Final Report - Corrections Required **Application No. DEPN-26-0013**

Description : Development Plan to establish internal roadways and lots. No end-users are proposed with this development plan application.

Address : 0 BRADLEY RD Colorado Springs CO

Document Filename : DP_V2_06-24-26

DEVELOPMENT PLAN
COVER

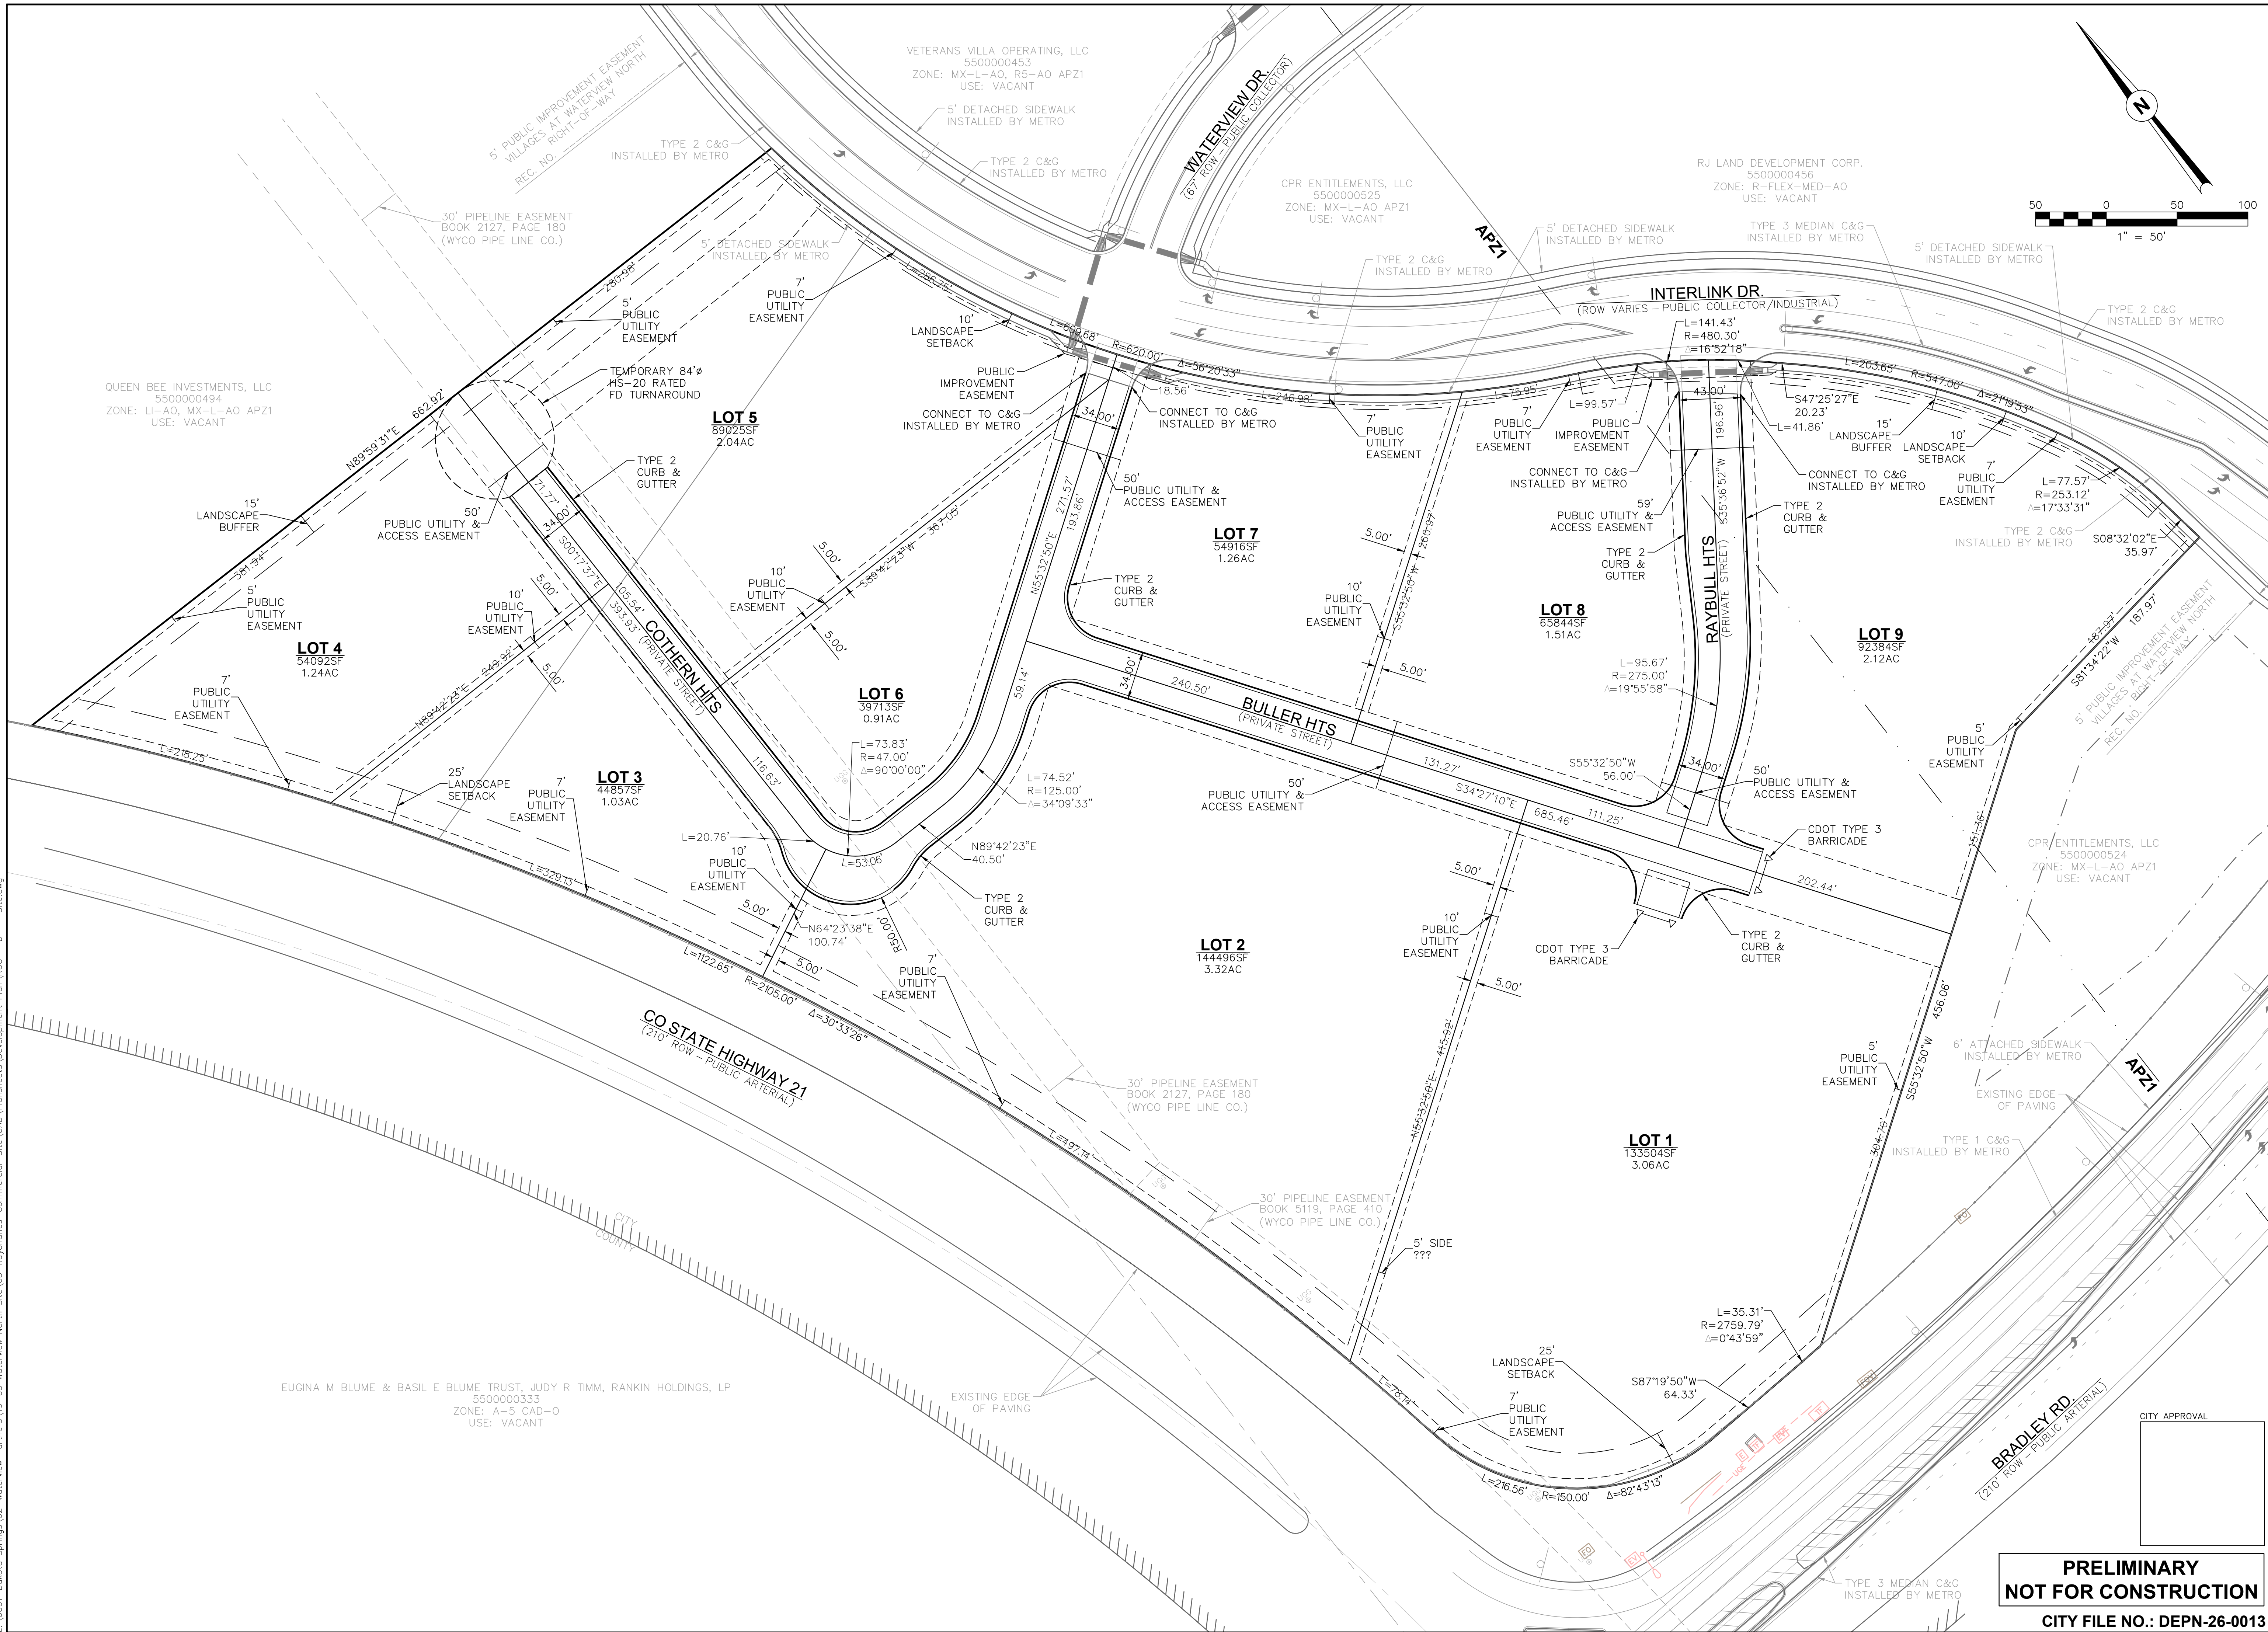
85	1	Drew Foxx : Planning	Provide name of metro district.
86	1	Drew Foxx : Planning	Veterans Victory Fil No. 1 does not encompass this site. I'm not sure it is correct to state that the aviation easement applicable to this subdivision establishes the aviation easement for this subdivision. Please confirm with CS Airport.
87	1	Drew Foxx : Planning	Please place all ADA standards in its own block. Ensure the following is included: Accessible parking spaces, access aisles, and signage shall meet all applicable City code

89	1	Drew Foxx : Planning	Revise the master and concept plan line items to include their titles: Title_File Number
90	1	Drew Foxx : Planning	All building setbacks are N/A for this zone district. Please revise.
91	1	Drew Foxx : Planning	While this note may be addressing the metro districts responsibility to build the private roadways, please either add to the note or create a new note addressing the continued maintenance and ownership.
81	2	Drew Foxx : Planning	Previous comment not addressed: Label zone and use classification for this parcel.
92	2	Drew Foxx : Planning	Per 7.4.403.C.8: On stub end streets designed to provide future connection with adjoining unsubdivided areas, there shall be provided a temporary turnaround at the stub end or a temporary connection to another street if required by the City Engineer or Fire Code Official. If such a provision is required, the design for such stub end or connecting street shall be approved by the City Engineer and Fire Code Official.

Please place all ADA standards in its own block.

Revise note 21: This is not a correct statement. There are several uses that are not permitted within the APZ-1 within the industrial/commercial land use categories.

Please remove Note 23

Revise: Future development of each lot shall be subject to additional development plan applications for review by City Planning.

Remove due to revisions to note 28.

All building setbacks are N/A for this zone district.

Revise the master and concept plan line items to include their titles: Title_File Number

DEVELOPMENT PLAN
SITE PLAN

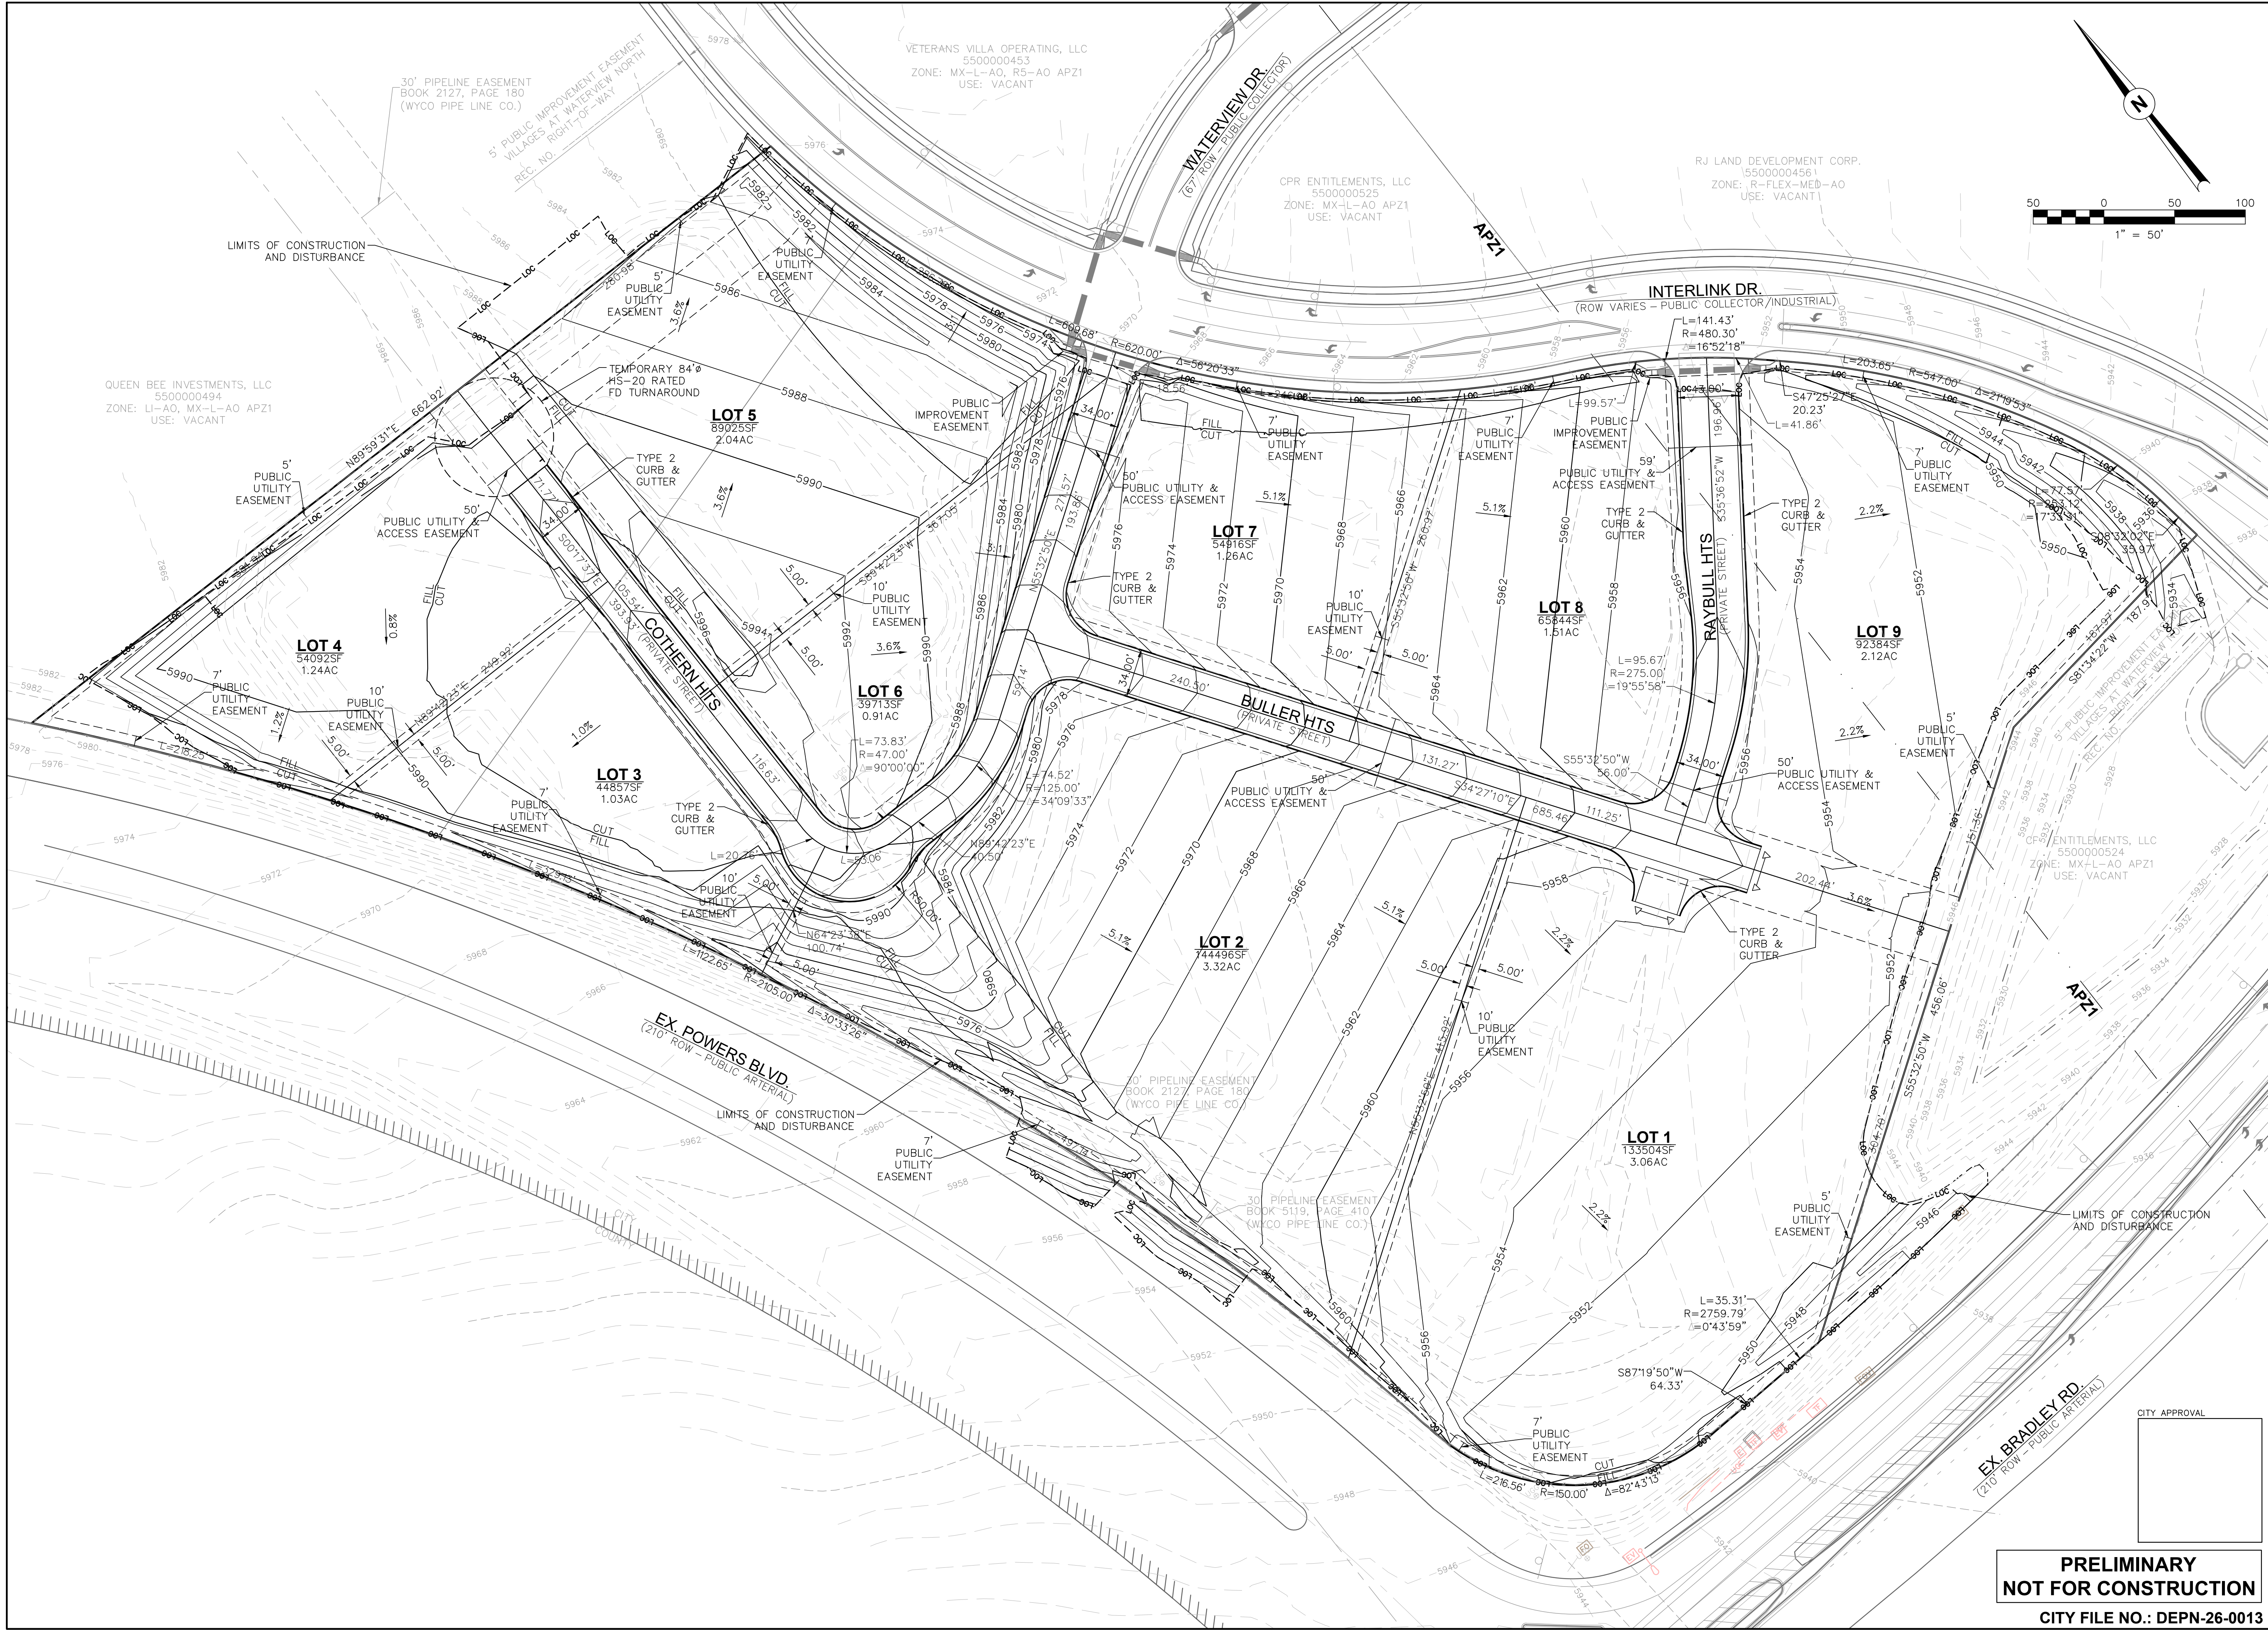
94	2	Drew Foxx : Planning	Comment not addressed: Add width and reception number of all public utility and access easements.
